Please ask for: Nicola Moore
Email: nicola.moore@arun.gov.uk
Telephone: Ext 37944
Our Ref: AW/130/22/HH
Your Ref:
Date: 29th June 2022

Application for Planning Permission for Works or Extension to a Dwelling

Development: Proposed rear balcony. Removal of pitched roof and replace with new flat roof.
Location: 37 Grosvenor Road Aldwick PO21 3EZ

AS EXISTING

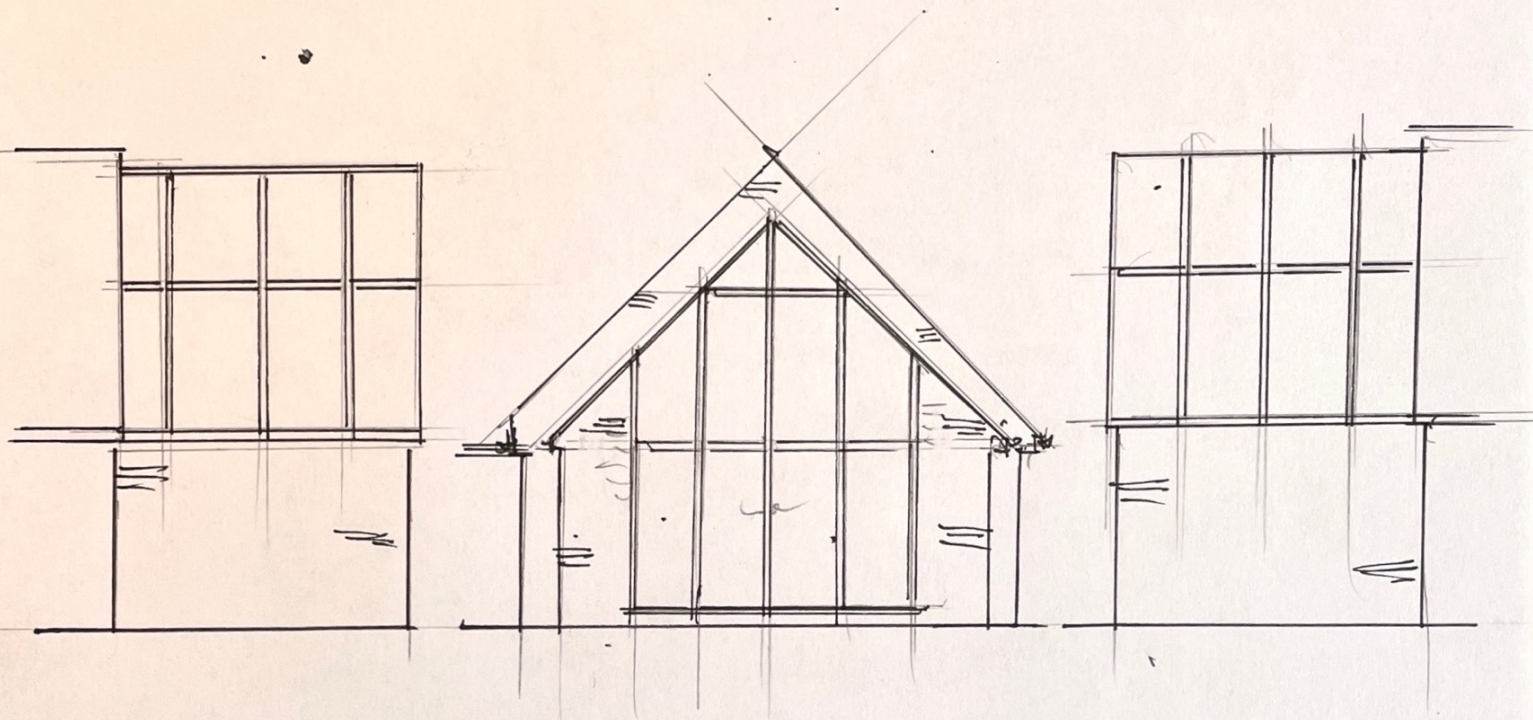
Please submit clearly labelled existing elevations.
